23/00750/TEL56 – comments from Kirtlington Parish Council

Proposed 5G Telecommunications Installation at Station Road, Kirtlington

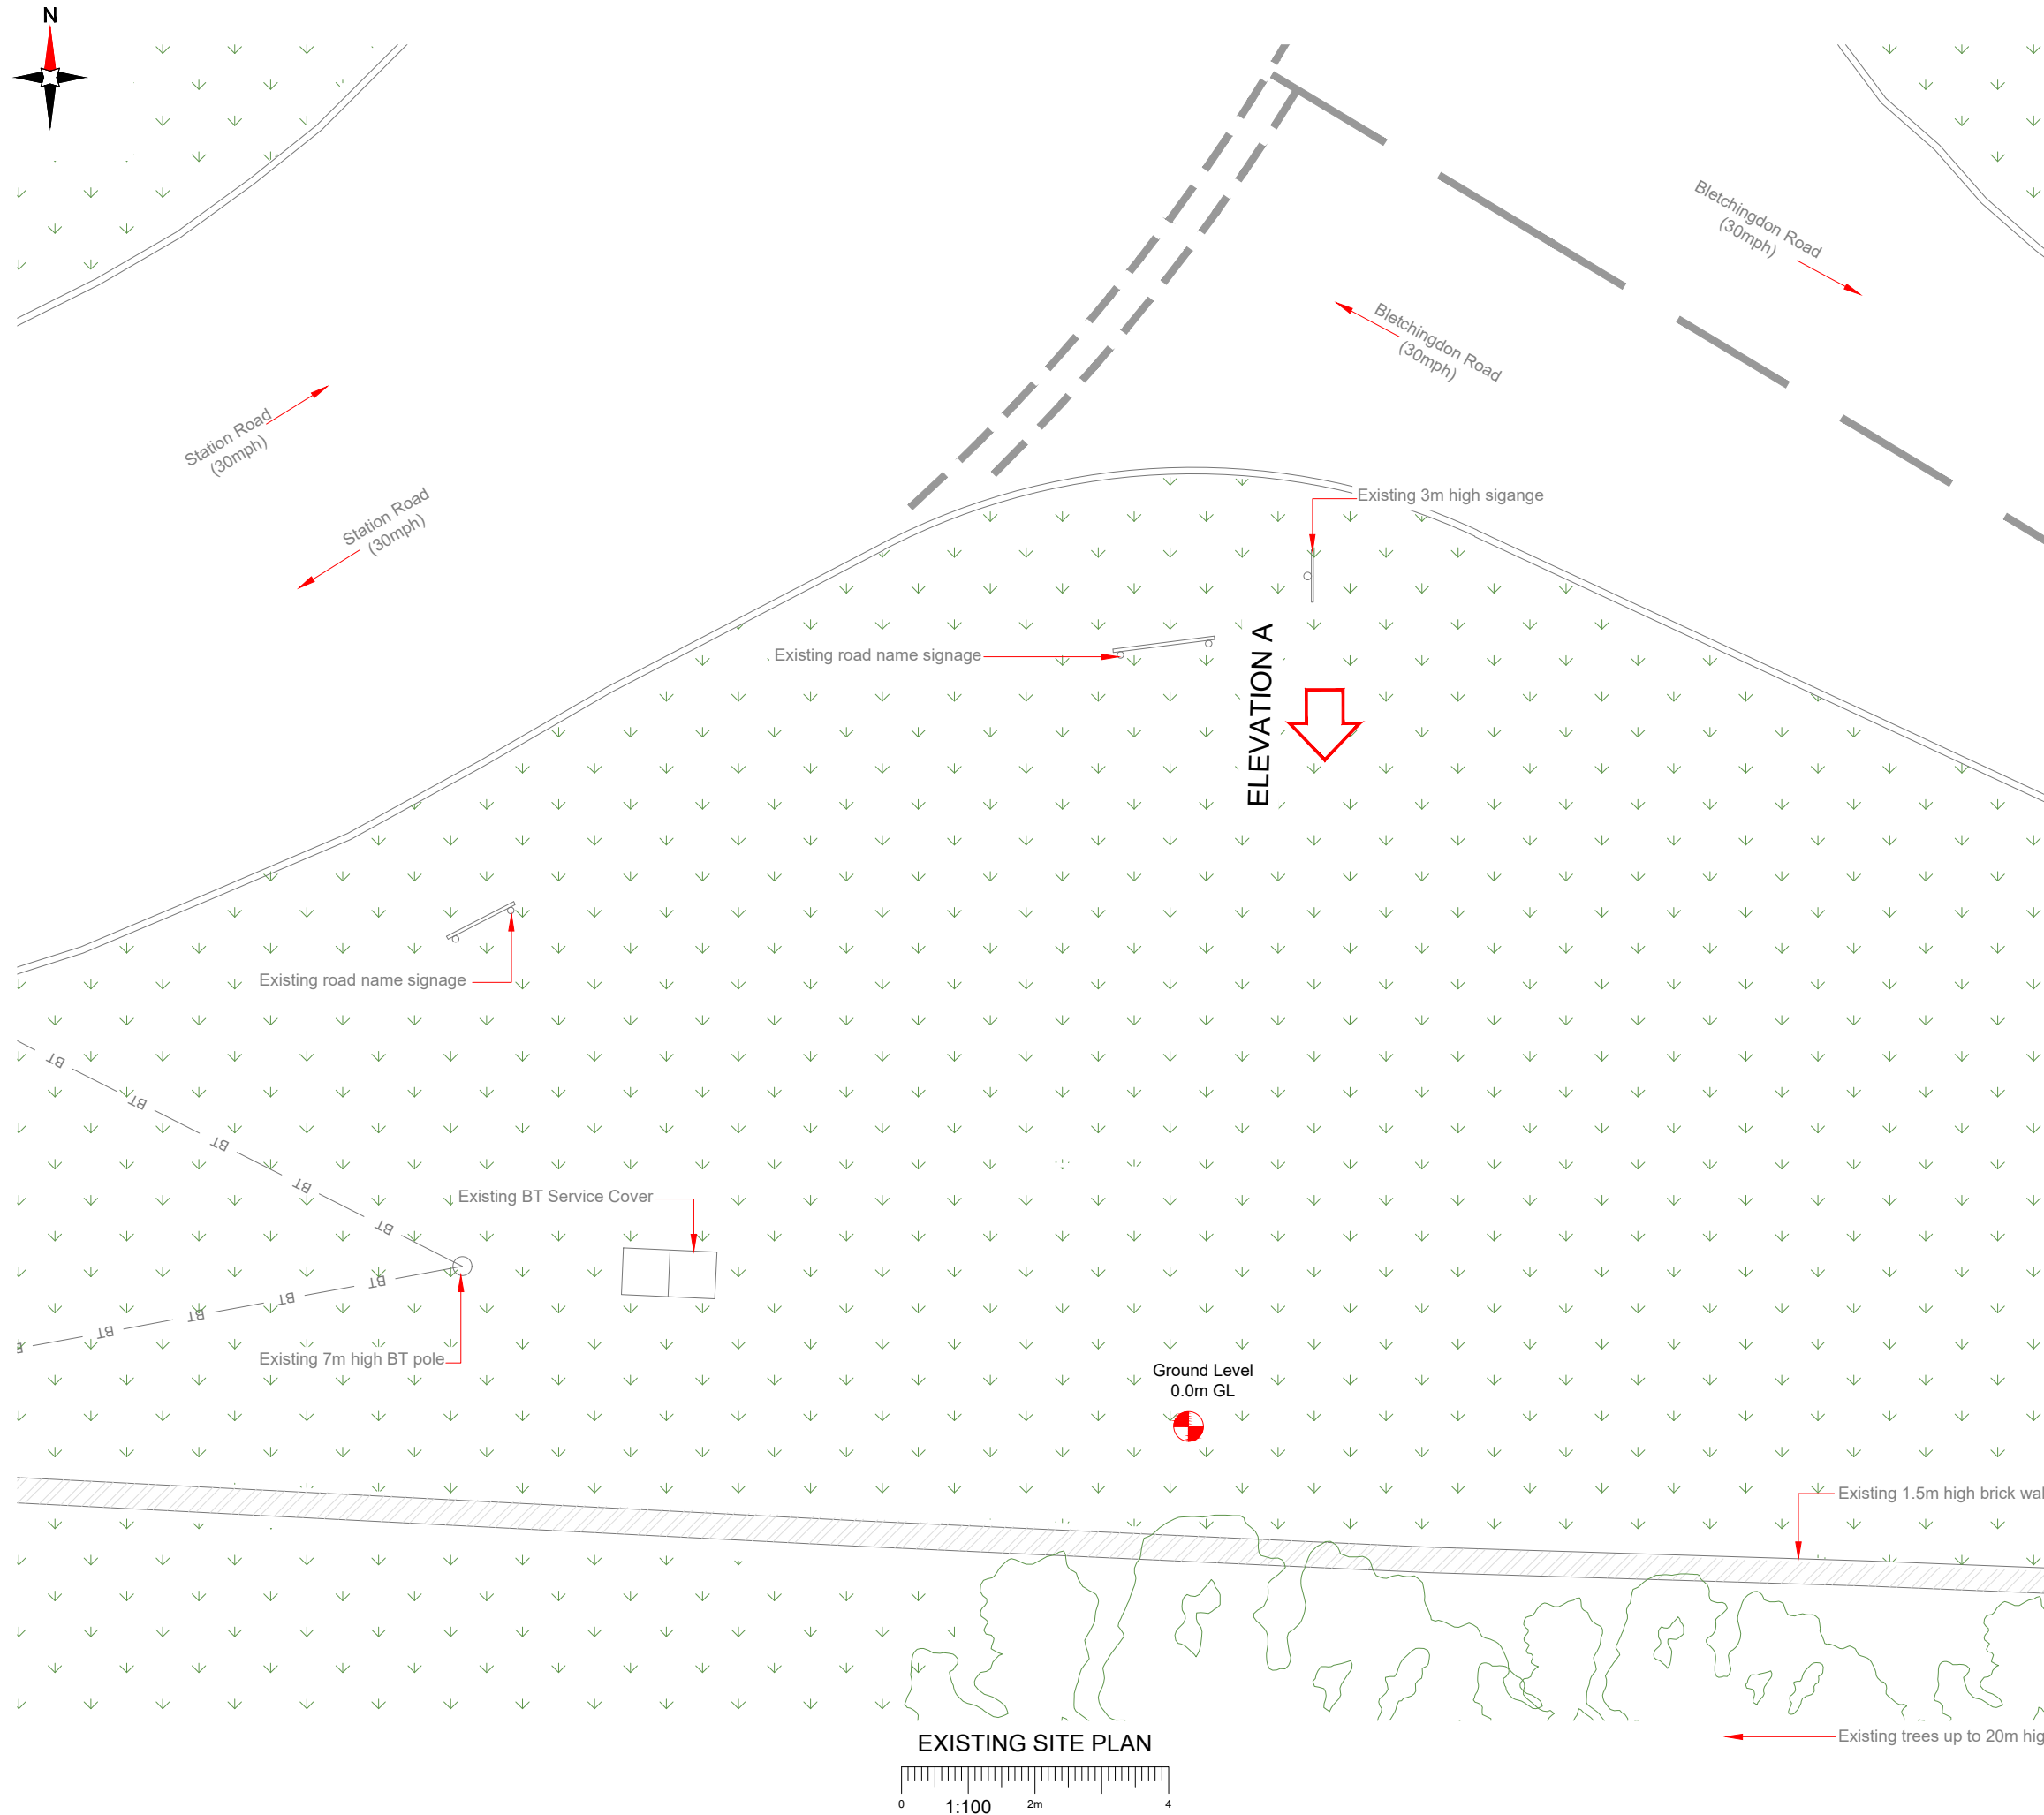
The location of the site is a wide grass verge (in the ownership of the Highway Authority - Oxfordshire County Council) within the south-western edge of the Kirtlington Conservation Area (refer to Kirtlington Conservation Area Appraisal (CAA) by Cherwell District Council, September 2011). The site is a visually prominent position at the junction of three main approaches at the southern end of Kirtlington:

- Oxford Road from the north (A4095);
- Lince Lane/Station Road from the west (A4095);
- Bletchingdon Road from the east (C15178).

Within the CAA, the site is located within an area of local archaeological interest (Area 8 on Figure 7 of the CAA is purported to contain the potential remains of the shrunken Medieval village and the toll house). The presence of the 15m high monopole and the associated cabinets would thus not only fail to conserve the visual appearance of this part of the Conservation Area, (being prominent in views experienced by travellers along all three roads approaching the site) but could also impact on the physical remains of underground archaeology.

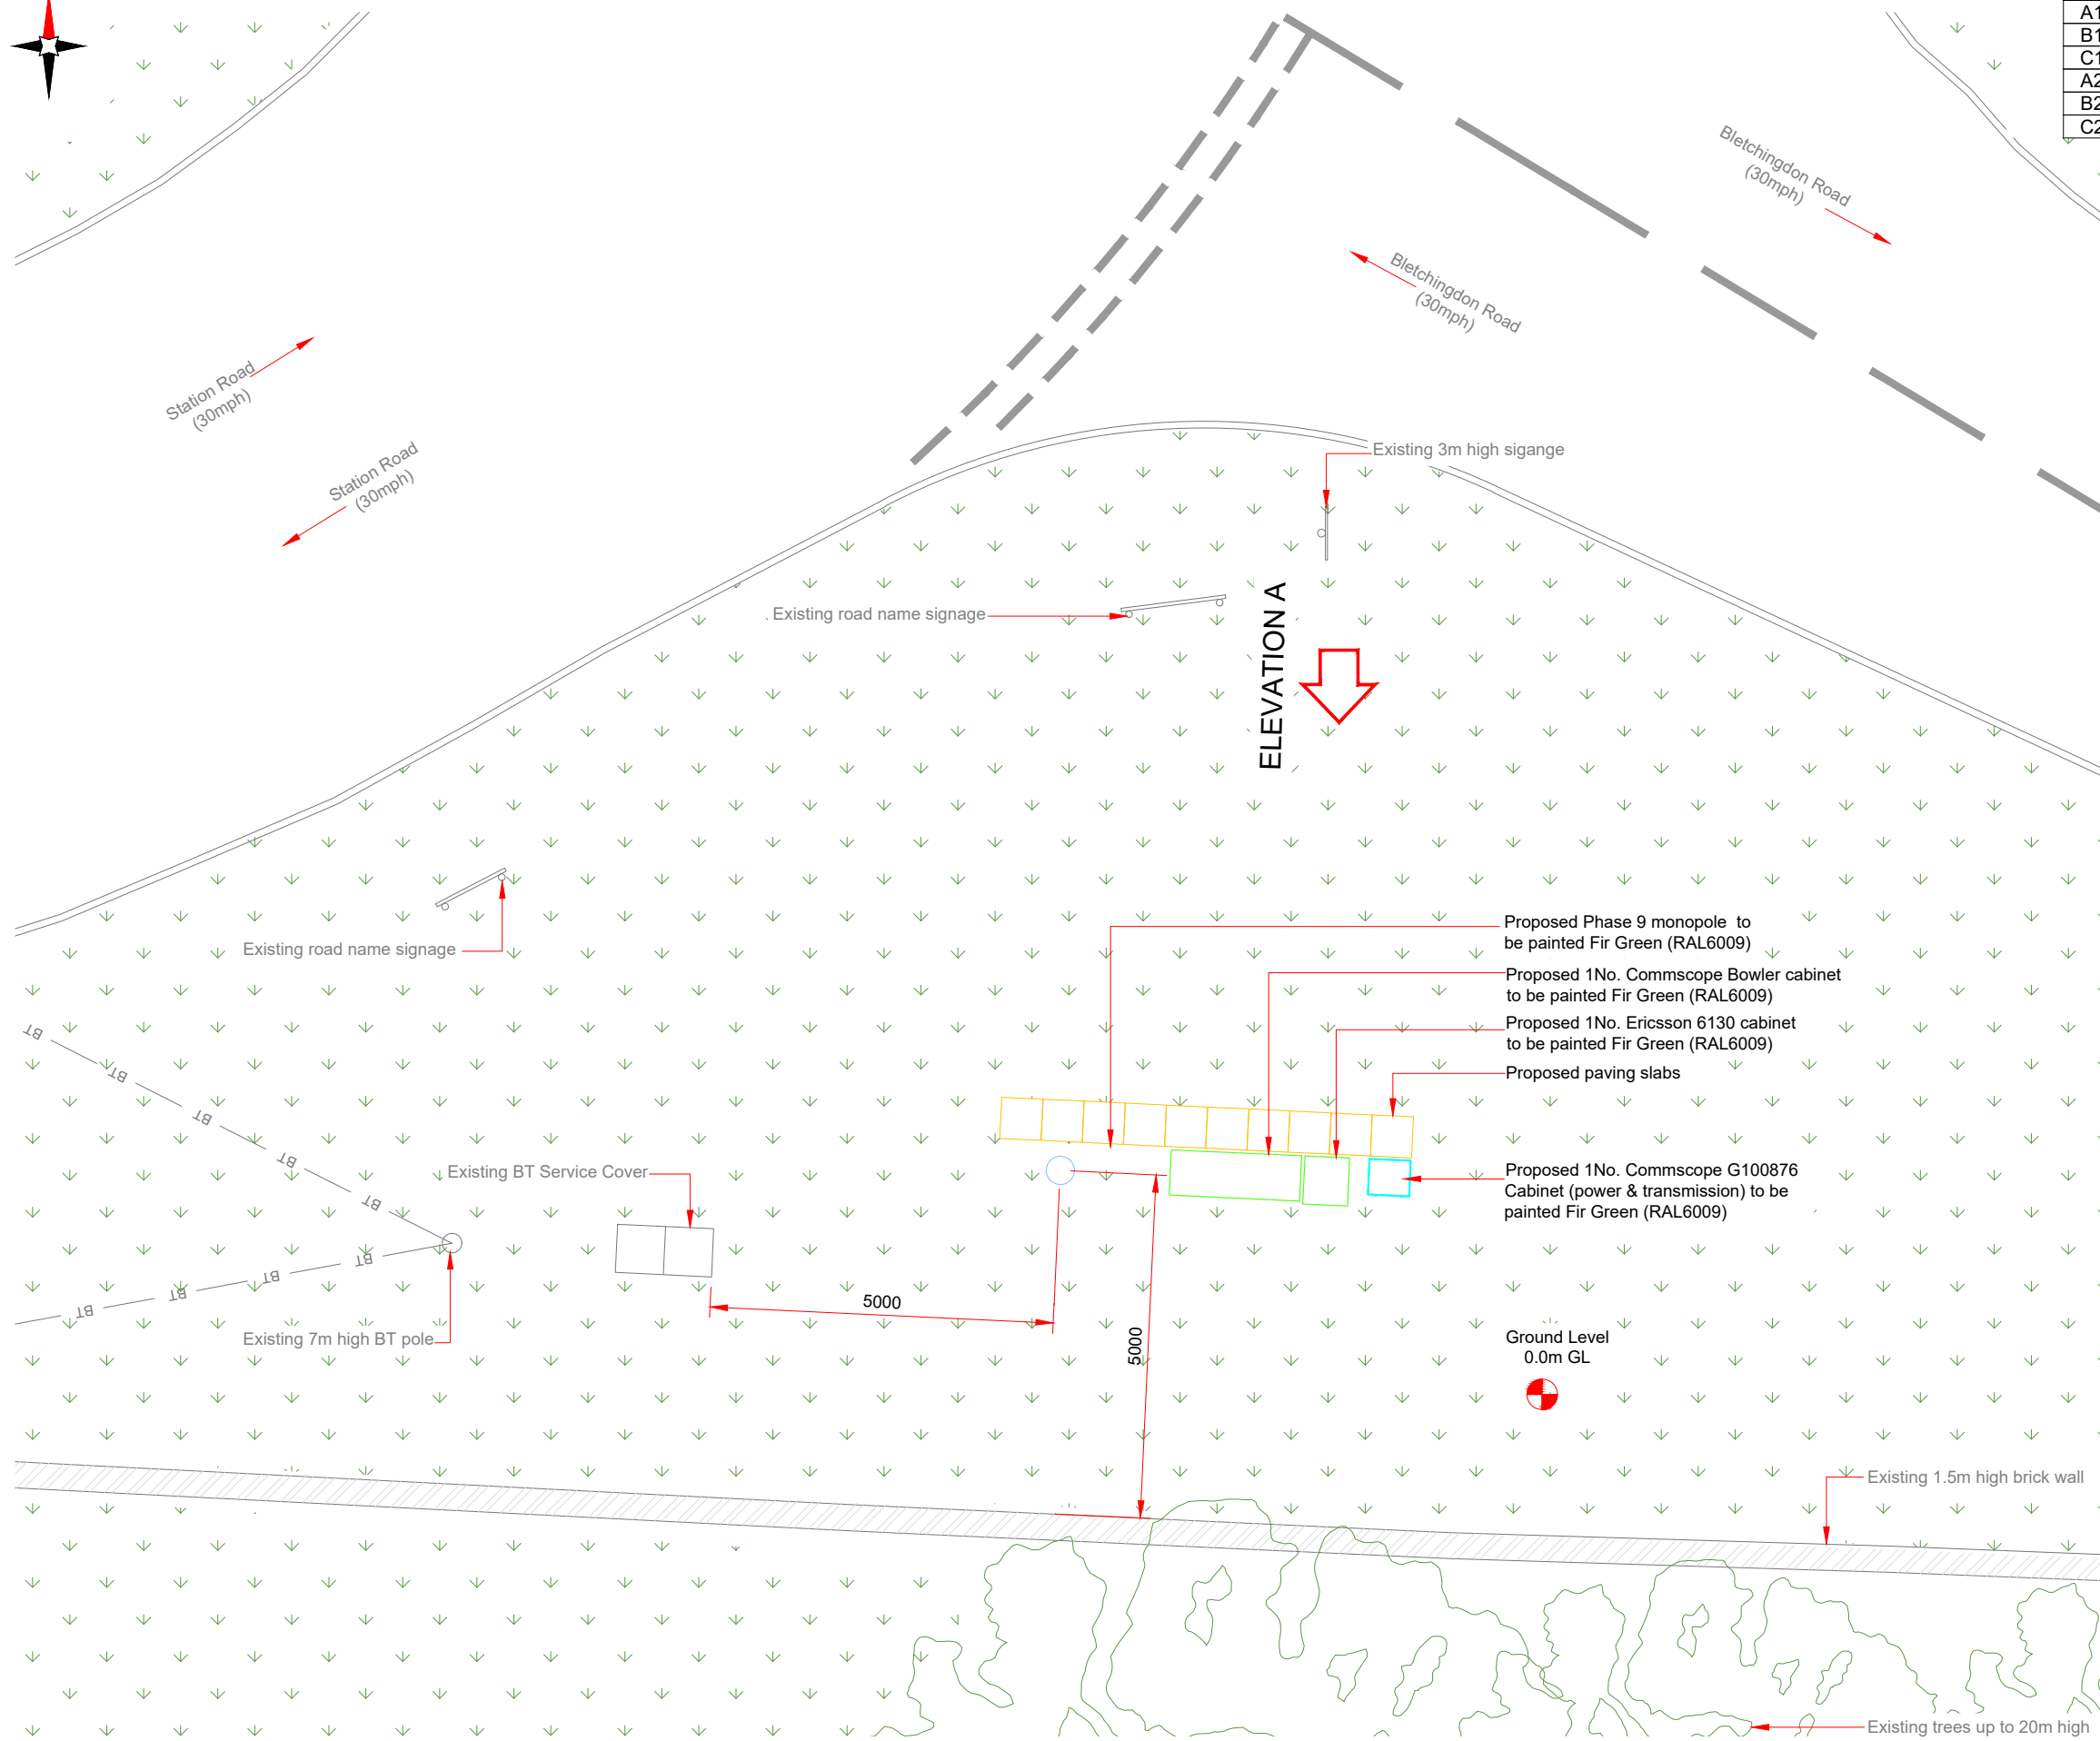
This broad junction has a generally open character, created by the wide, grass verge upon which the mast is proposed, and when this is combined with the large area of grass verge on the north side of Station Road, the area has a sense of openness that is as important in defining the character of the village as are the North and South Greens. It is considered that, other than positioning the proposed mast on the Greens, a more visually intrusive location for this development would have been difficult to find.

The SSSI suggests that the proposals "*would be suitably distant from potentially sensitive users*" (page 6) but fails to identify what is deemed to be a sensitive user and what would be a suitable distance between such users and the proposed development. Evidently, residential amenity is considered to be a limiting factor, referring to "this densely packed residential area (page 10). It should be noted that the applicant's preferred site lies very close to the following residential properties (with a) to e) lying within the CA):

- a) The garden of Willow Tree Barn lies immediately to the south of the verge, with the residential property located 37m from the proposed mast;
- b) Stoney Crest, to the east of the mast site, and 63m from the proposed mast;
- c) Troy House, (former Vicarage), 46m to the north-east of the proposed mast;
- d) Red Rose Cottage and No 2 Troy Lane, 57m to the north of the proposed mast;
- e) Nos 2 and 3 Turnpike Cottages, 49m to the north-west of the proposed mast;
- f) Rosemount, 56m to the north-west of the proposed mast.
